MISFIT CREW ESTATES

MINOR SUBDIVISION PLAT MISFIT CREW ESTATES	
MVE, INC. ENGINEERS SURVEYORS 1903 Lelaray Street, Suite 100 Colorado Springs, CO 80909 719.635.5736 www.mvecvil.com	MVE PROJECT: 61160 MVE DRAWING: 61160-PLAT-CS DATE: MAY 21, 2024 SHEET: 1 OF 2

MVE PROJECT: 61160
MVE DRAWING: 61160-PLAT-PS1
DATE: MAY 21, 2024
SHEET: 2 OF 2

MISFIT CREW ESTATES

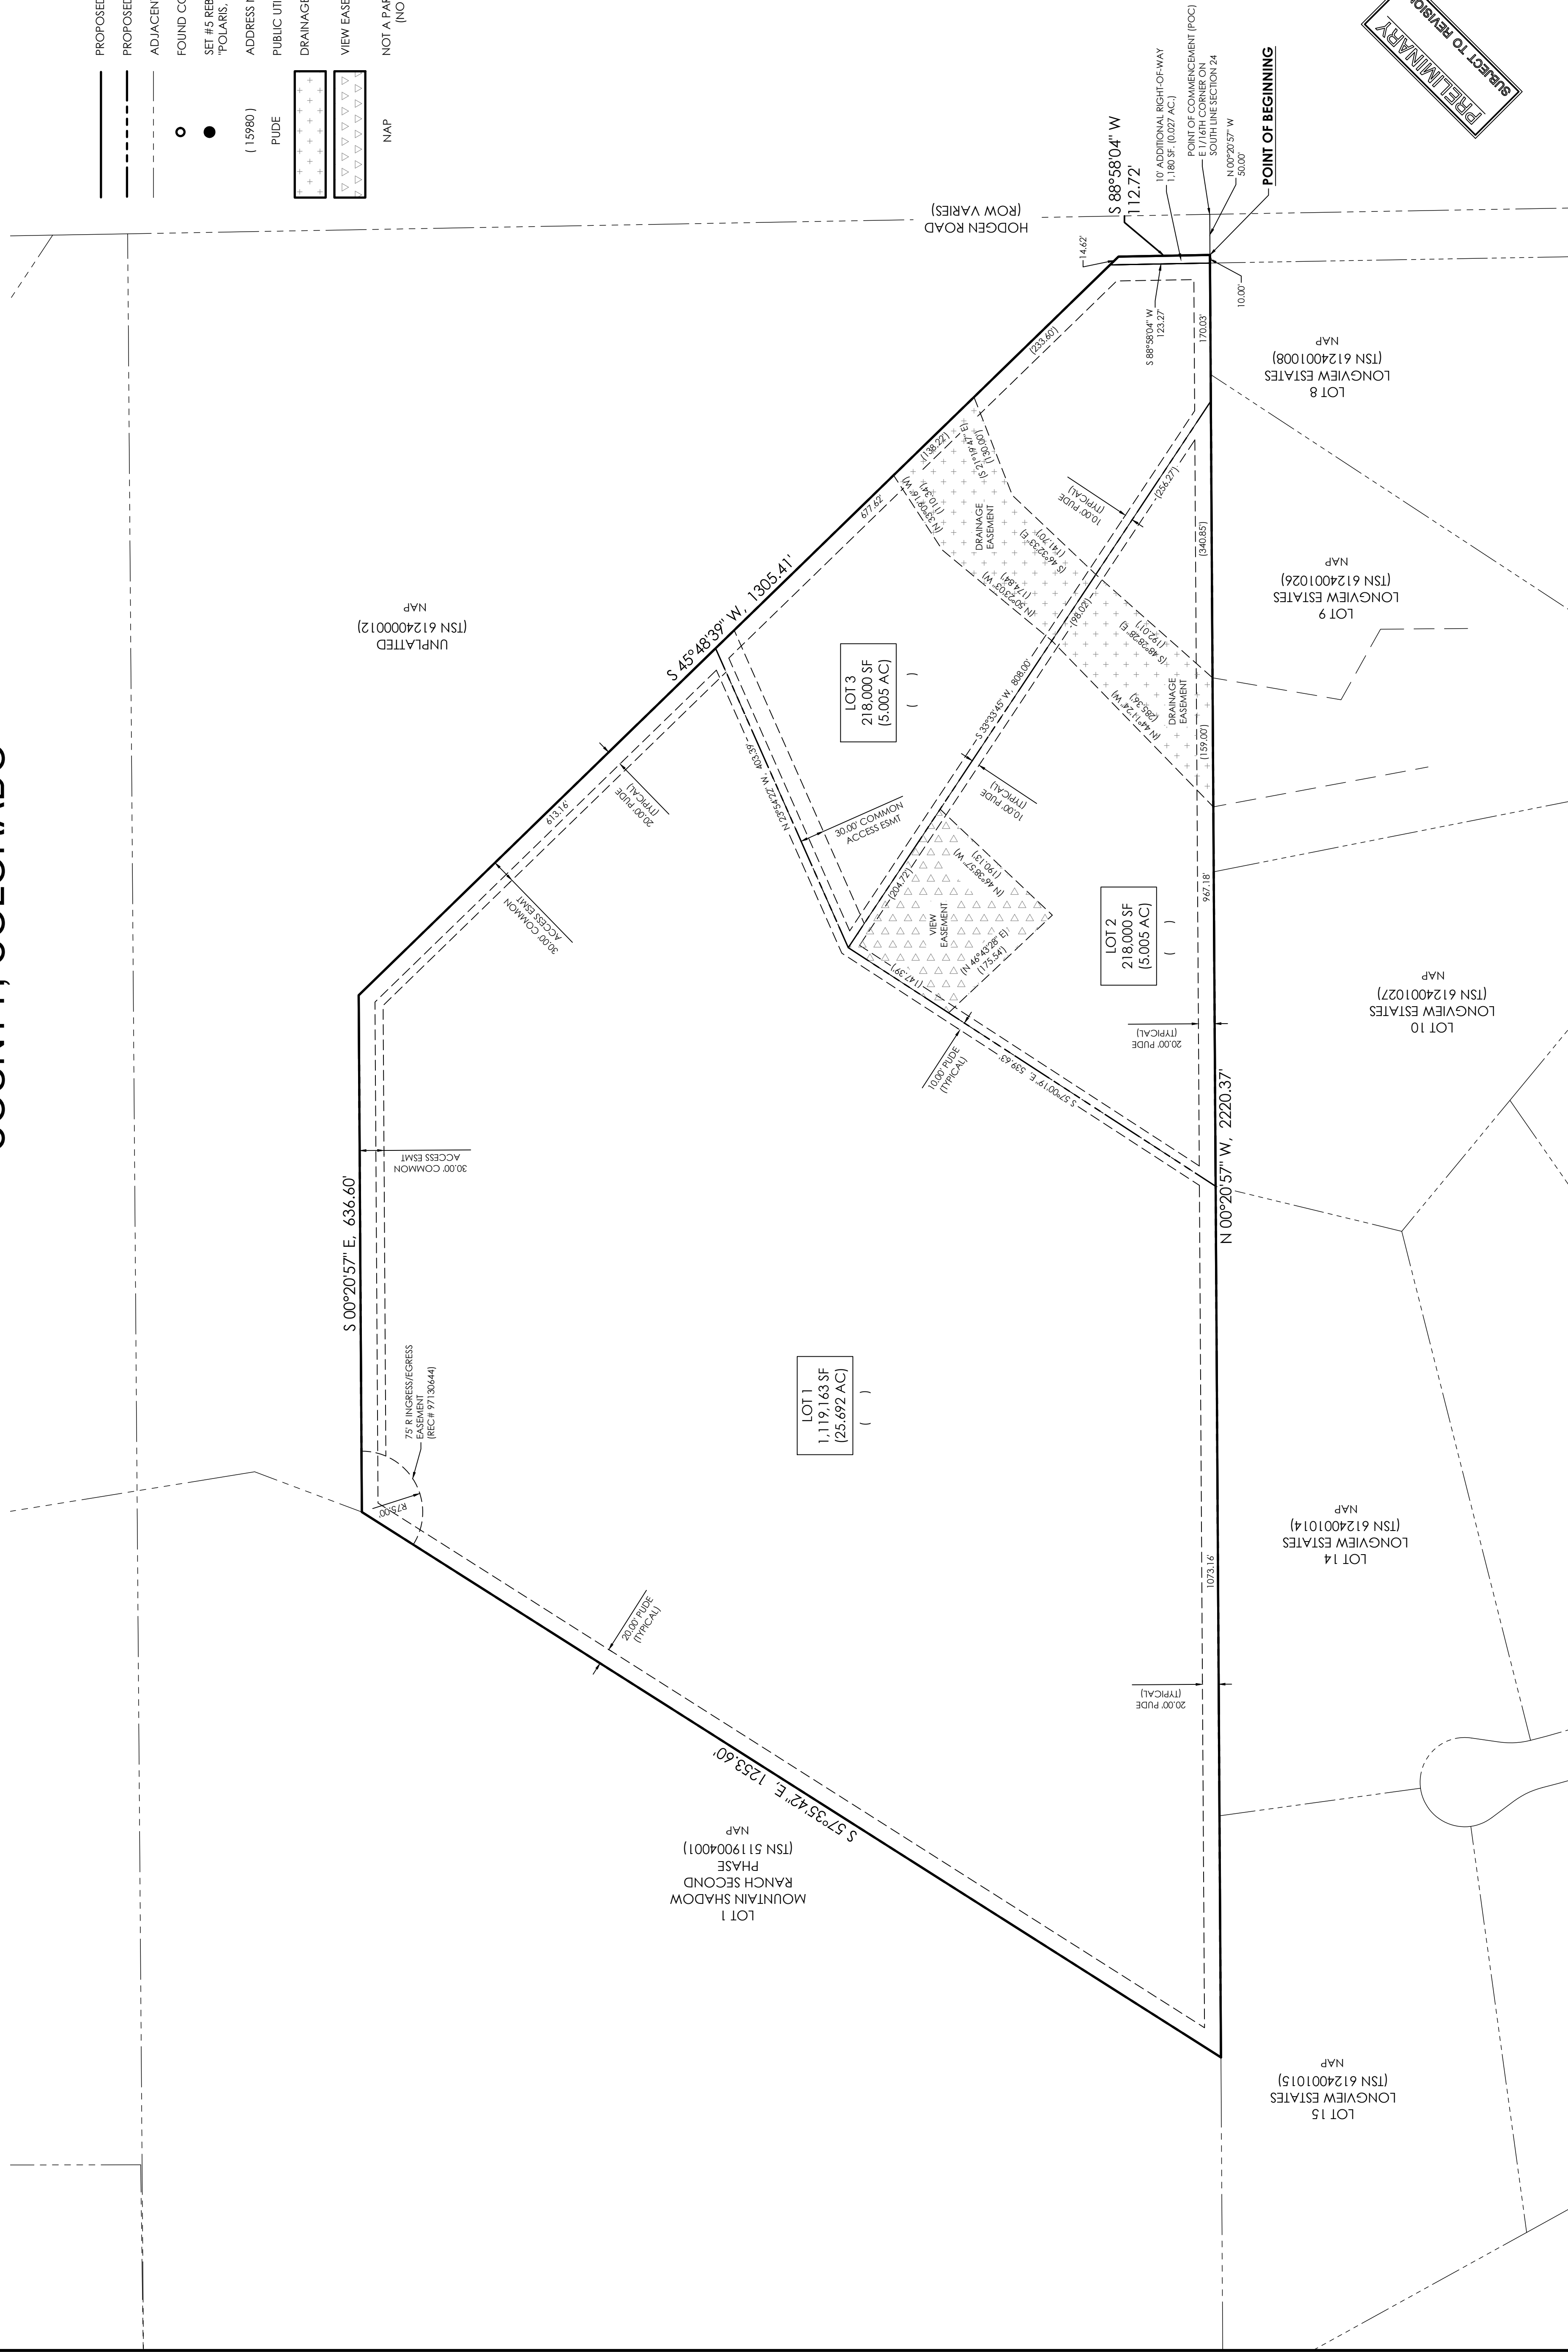
Show and label access easement for Mountain Shadow View, which gets to Lot 1. Include reception No.

Please label as "Private View Easement"

Label and dimension Hodgen Road as a Major Collector.

Please revise note: 10' Additional Right-of-Way to be dedicated to El Paso County.
